Engineers comments;

Subject: Planning Consultation on: BE/27/20/PL

APPLICATION NO: BE/27/20/PL

Description of Works: Creation of temporary soil storage bund & haulage route associated with development of adjoining site at Saltbox (resubmission following BE/38/19/PL). This application may affect the character & appearance of the Shripney Conservation Area & is a Departure from the Development Plan.

TOP SOIL RELOCATION  
 SITE PLAN  
 1744-TS-P02-E

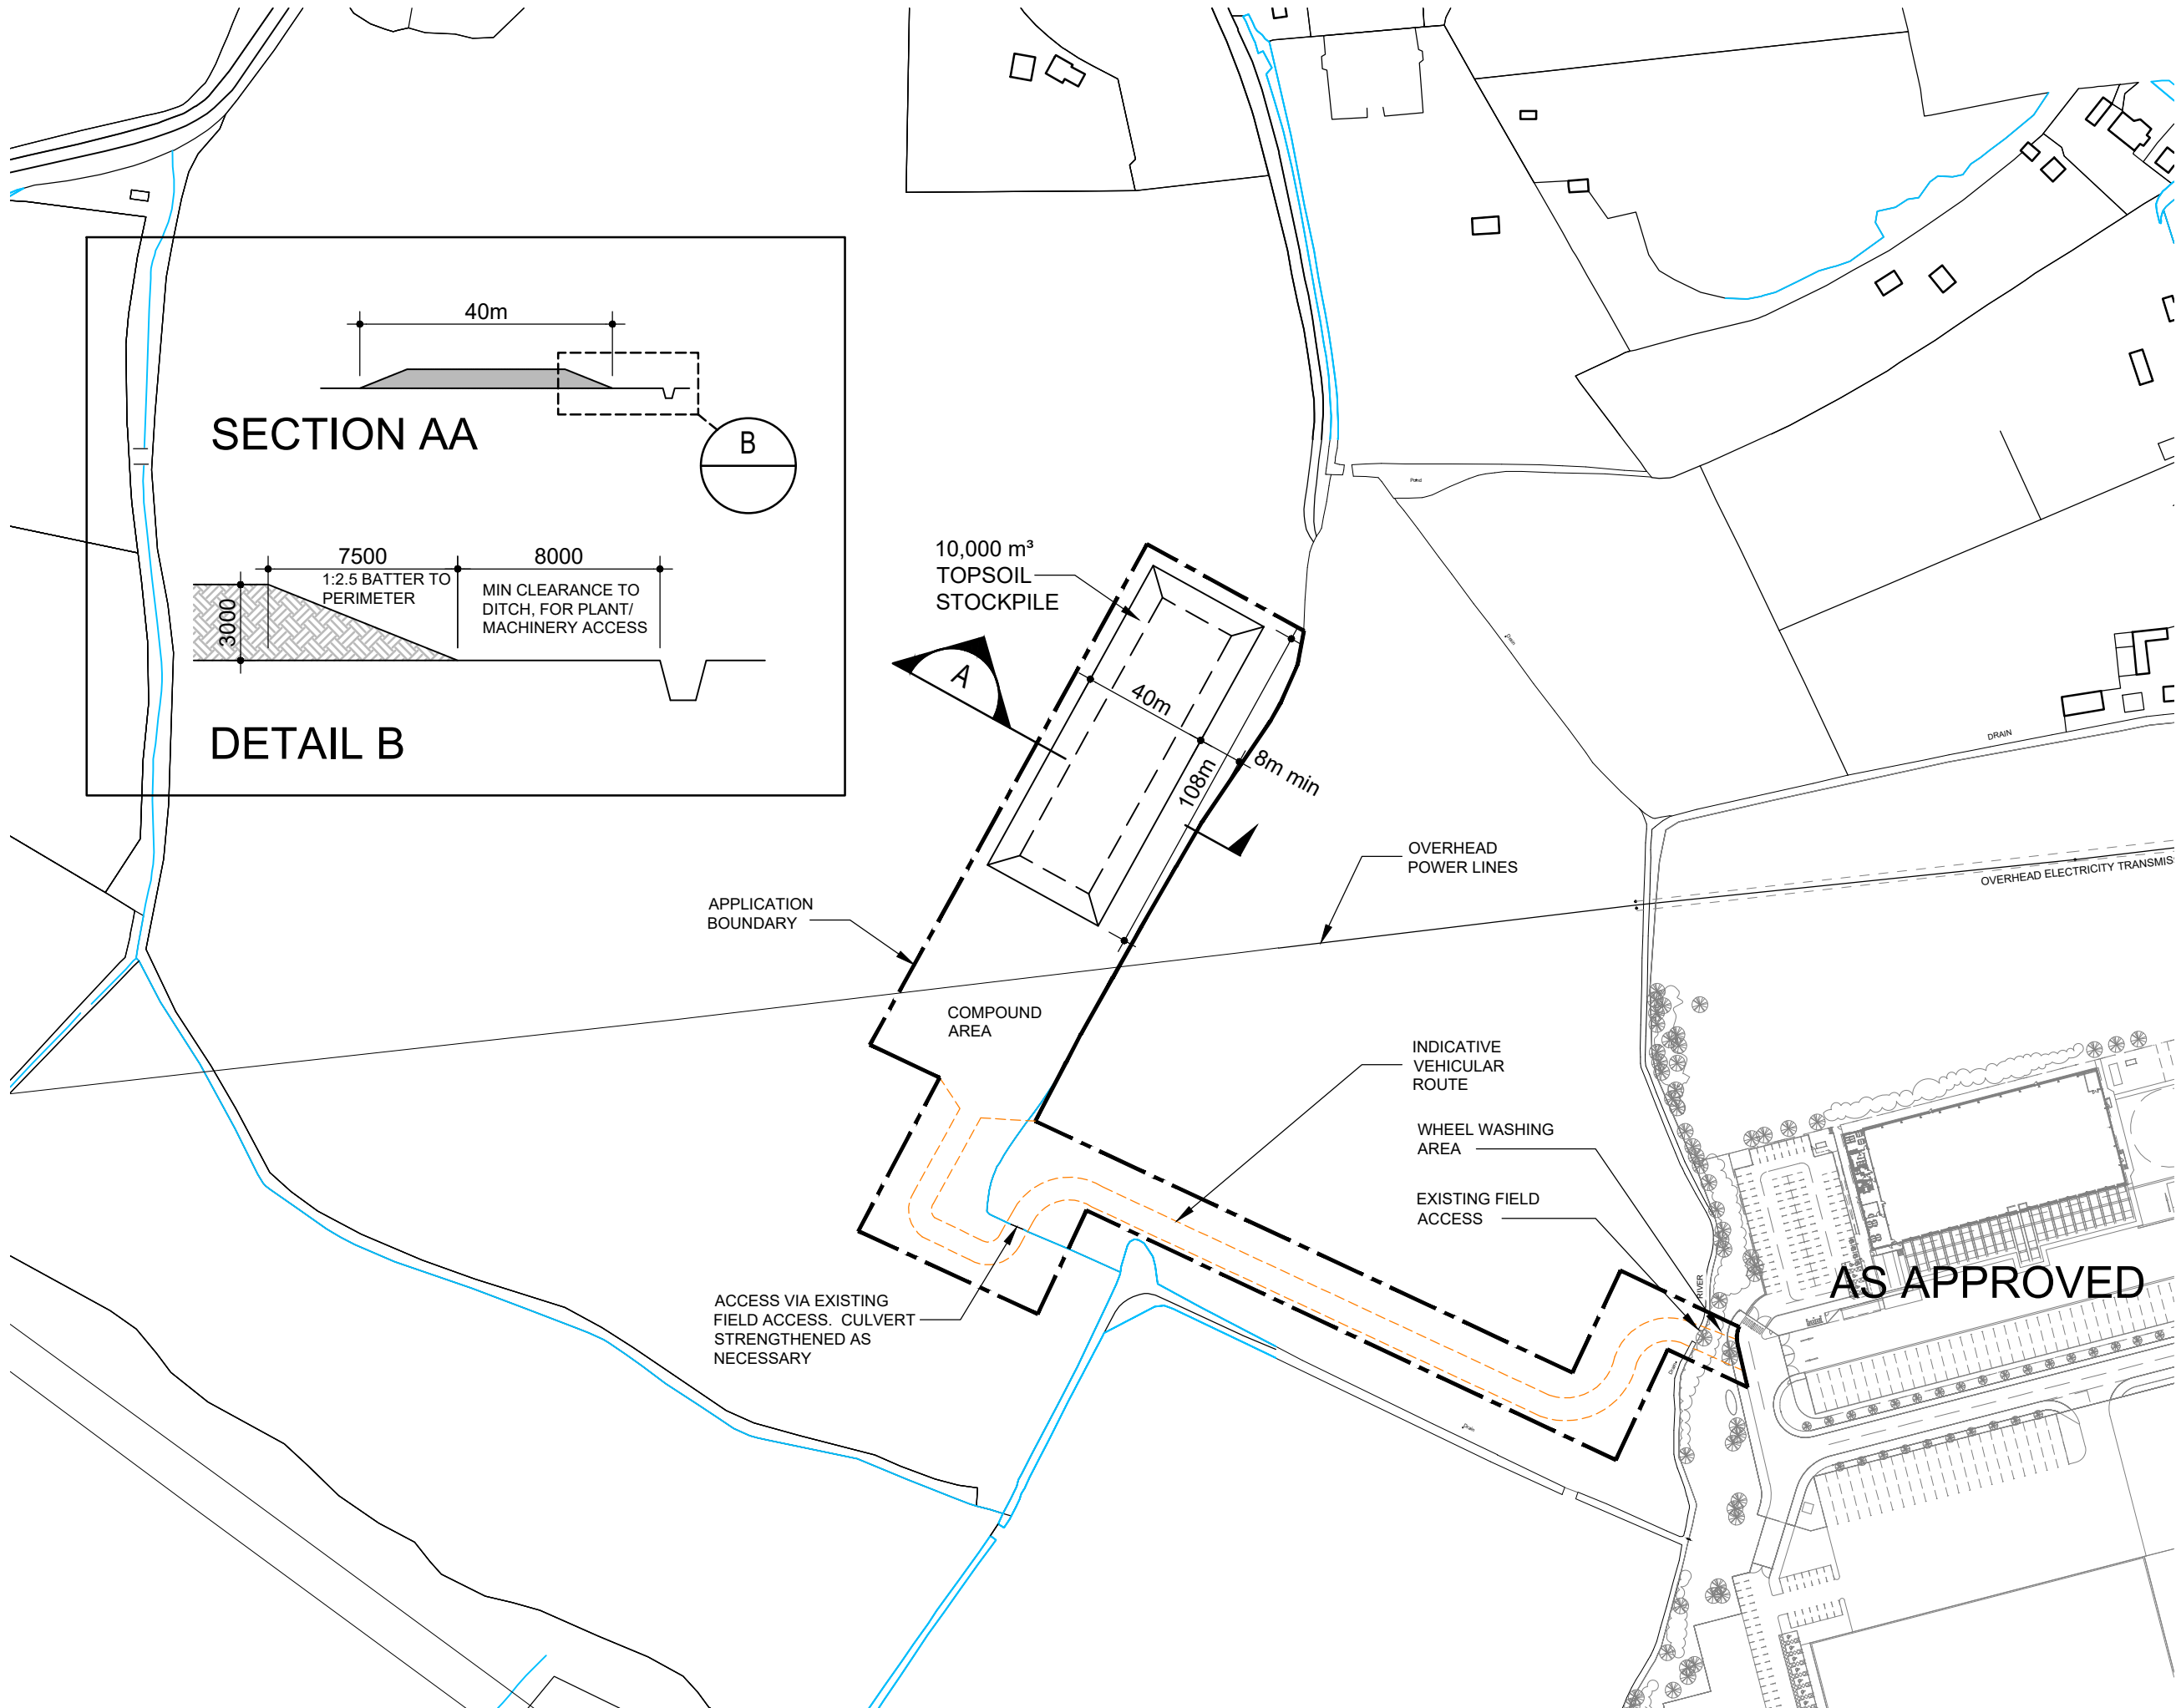
The proposal involves the proposed haulage road crossing existing culverts on the 'main river' section of watercourse and the 'ordinary' watercourse. It is noted that strengthening may be required on the ordinary watercourse culvert, in which case, the proposals will need to be agreed with ourselves. Any works to the main river culvert will need to be agreed with the Environment Agency (EA).

I note that the stock pile will be kept sufficiently clear of the watercourses.

The stock piled material is proposed to comprise of top soil only, and if that is the case, the applicant will not need to make allowance for introducing drainage around the perimeter. However, if the stock pile is to be covered with an impermeable membrane in order to prevent erosion/weed growth or consists of material less permeable than topsoil, then drainage measures will be required to ensure that the surface water run off does not increase flood risk elsewhere. Therefore, depending on the finer details of the proposal, it may be necessary to condition the application accordingly.
